**The Children's Hospital at Westmead – Paediatric Services Building (SSD-10349252)
Corner of Hawkesbury Road and Hainsworth Street, Westmead
Response to Submissions Report**

ATTACHMENT 1 – KEY ISSUES

Figure 5: Proposed bulk oxygen facility (Source: Appendix D Figure 1)

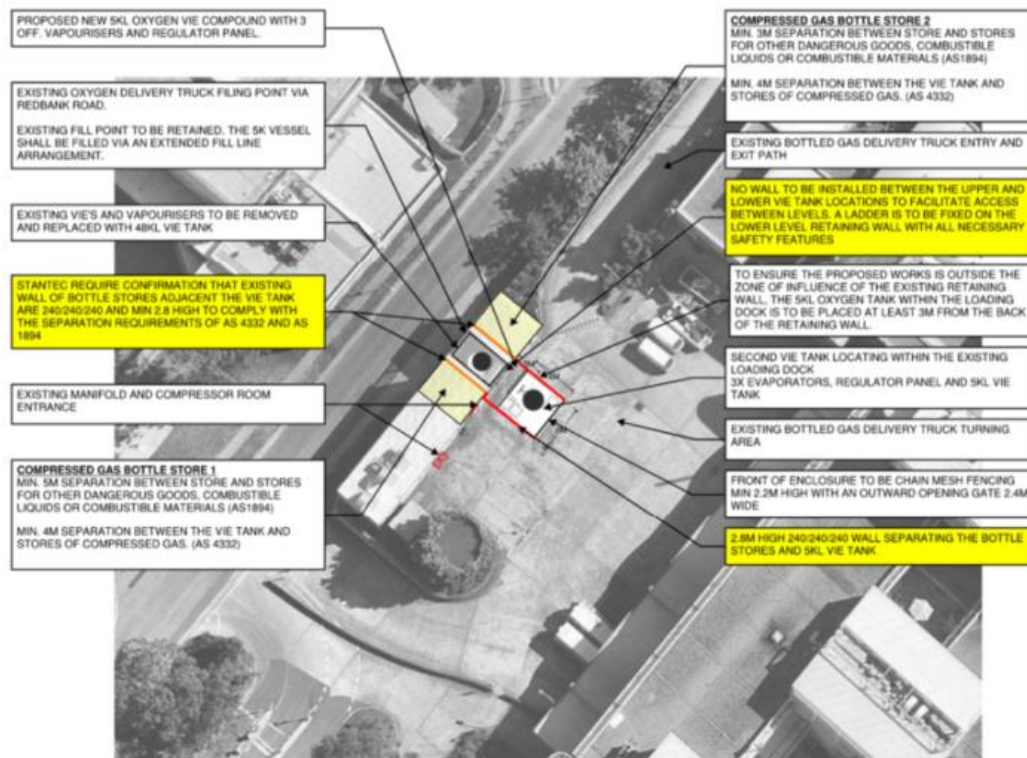
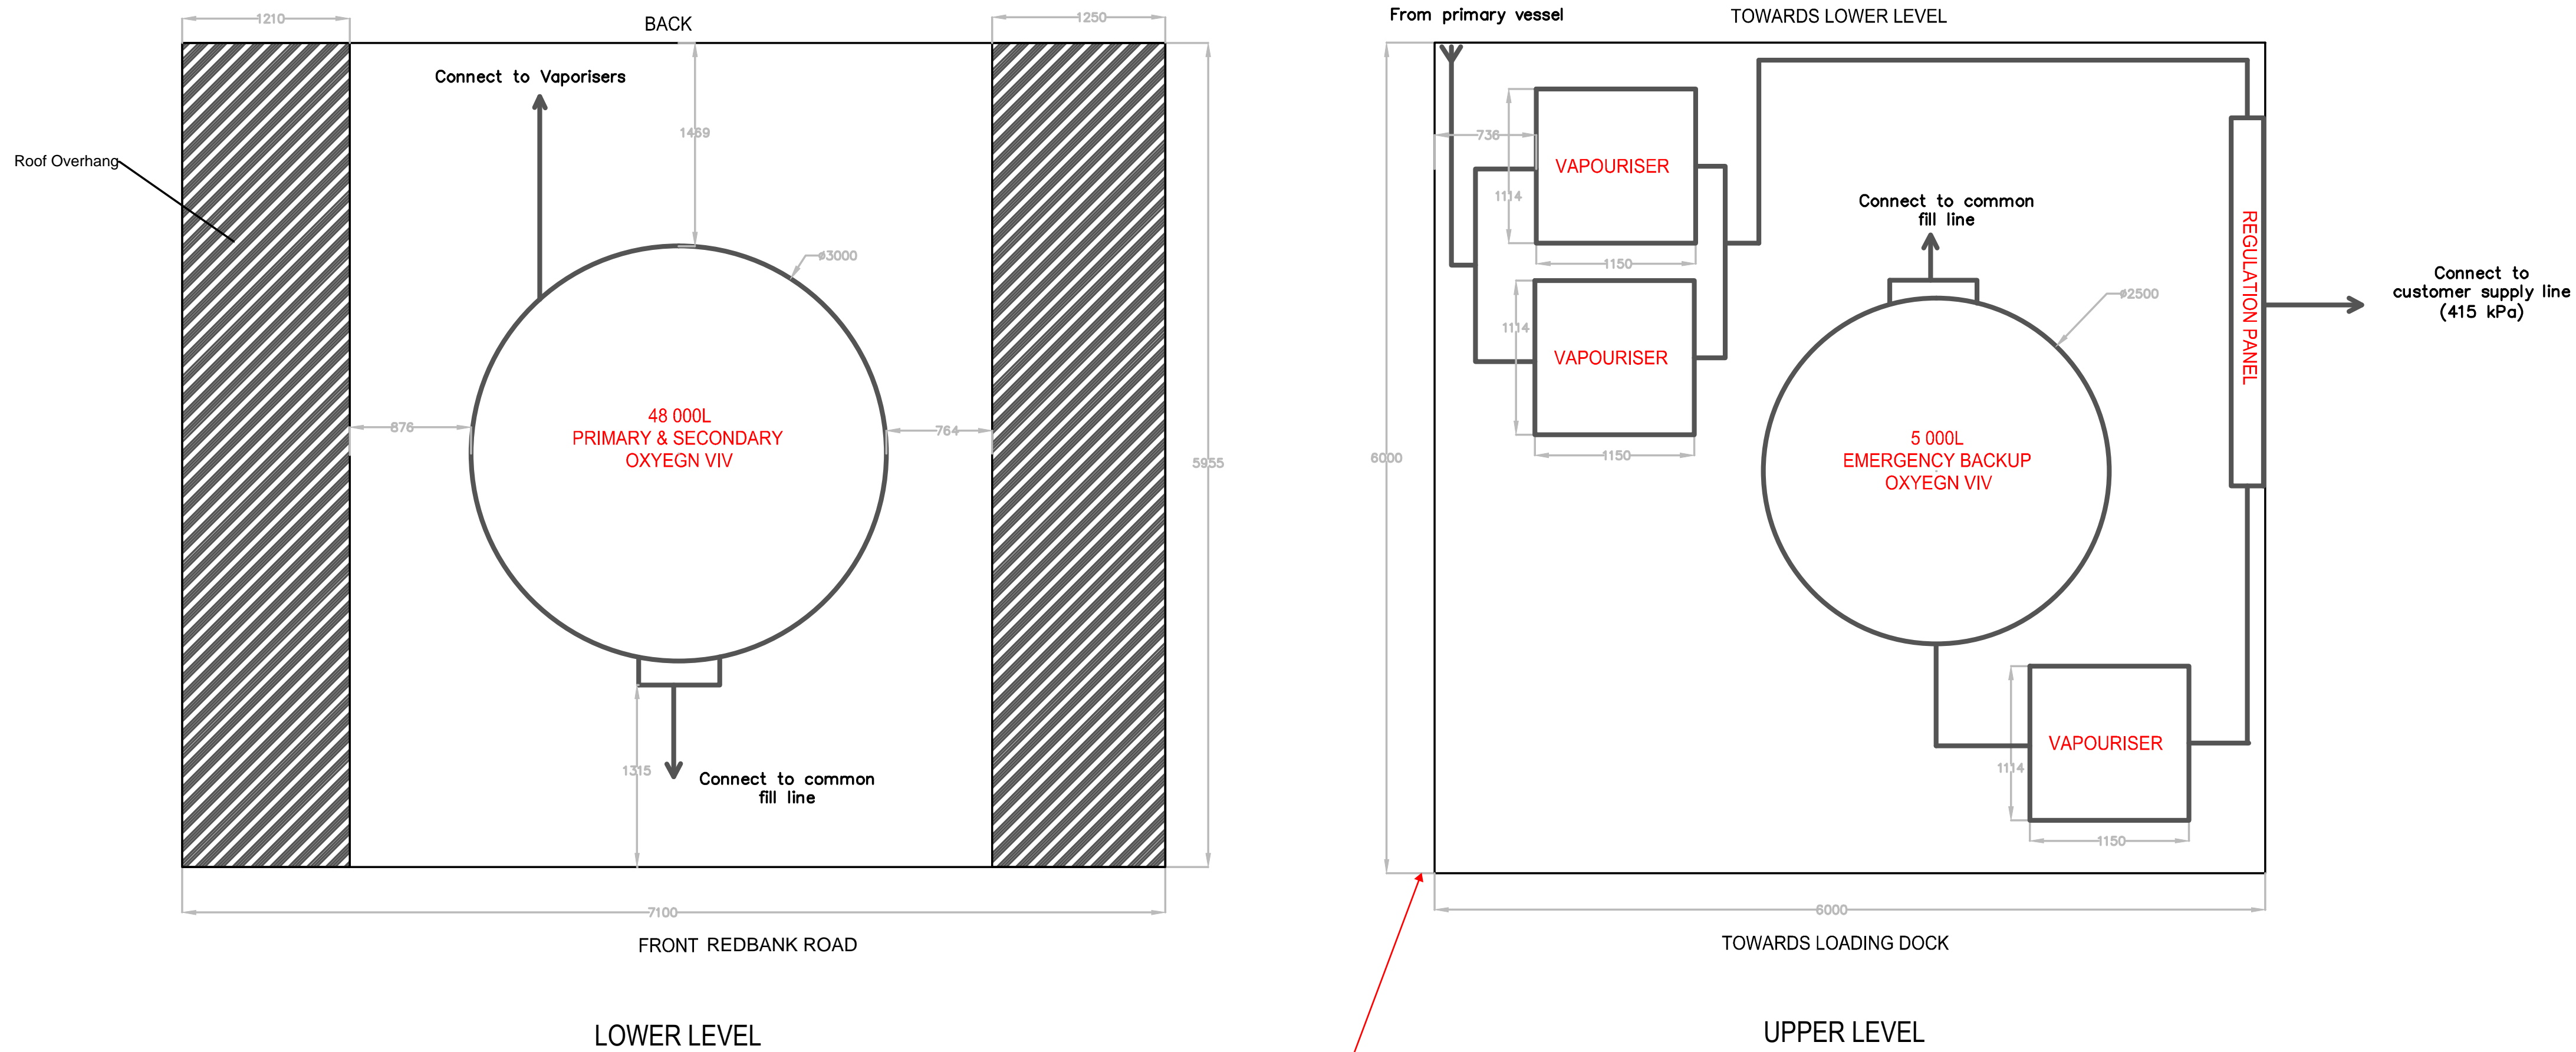
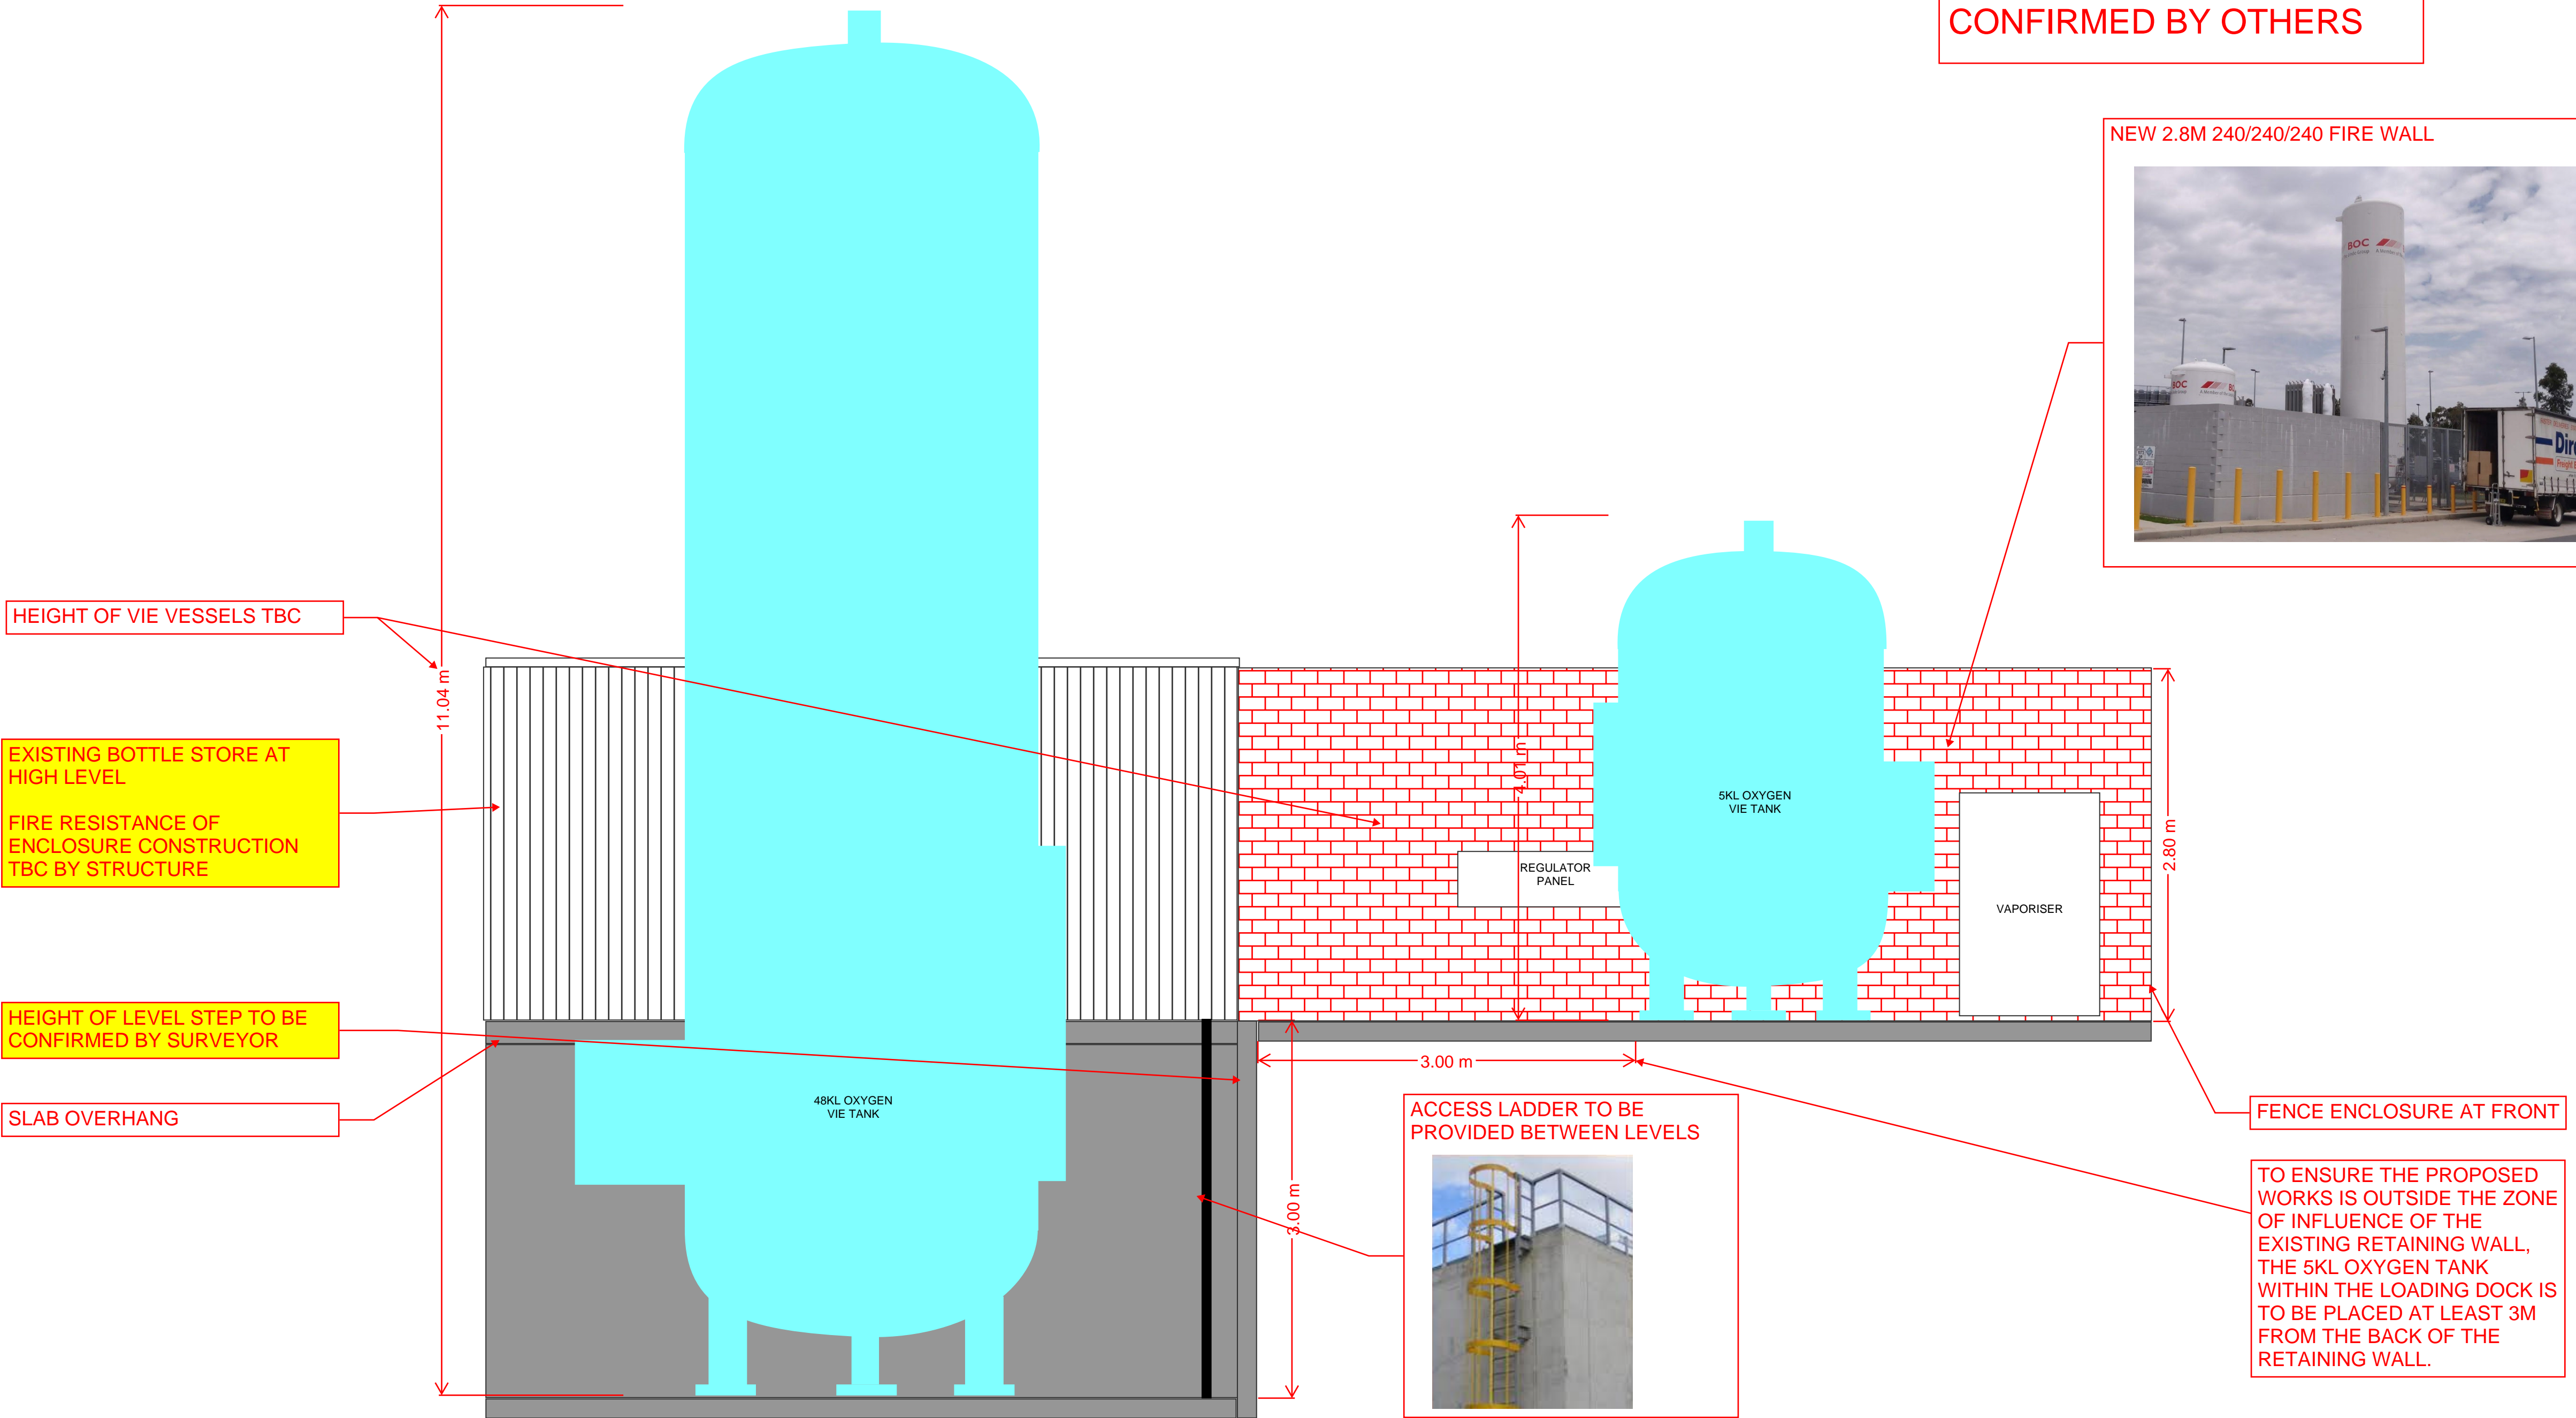
15. Confirm that the two liquid oxygen tanks are to be located within the loading dock area located to the south of Redbank Road as indicated in drawing CHW-AR-DG-PSB-SSD00 Revision A.

Figure 17: Classification of wind safety at 1.5 m above local ground level – external terraces/courtyards

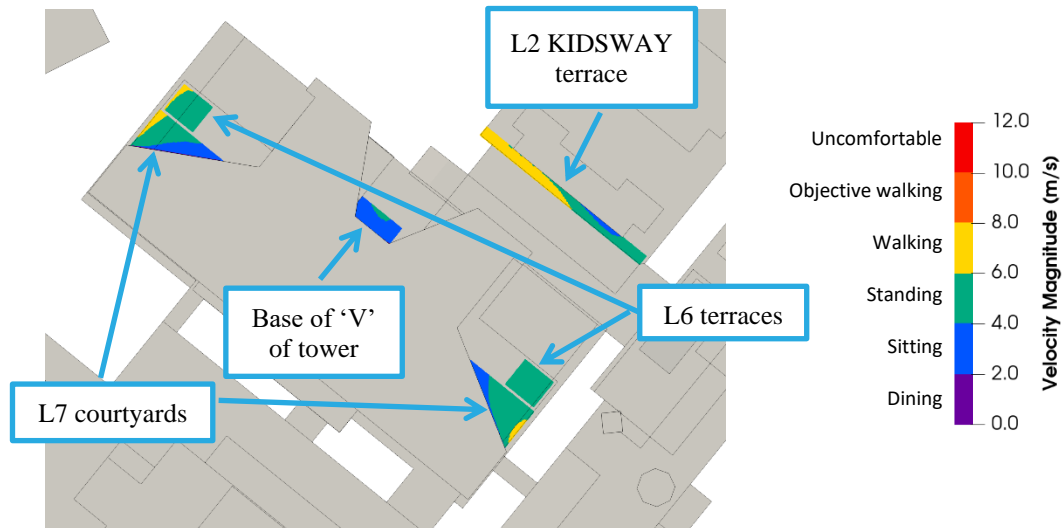
10. Provide further detail of the pedestrian comfort levels for each landscape terrace on the multiple levels of the PSB.
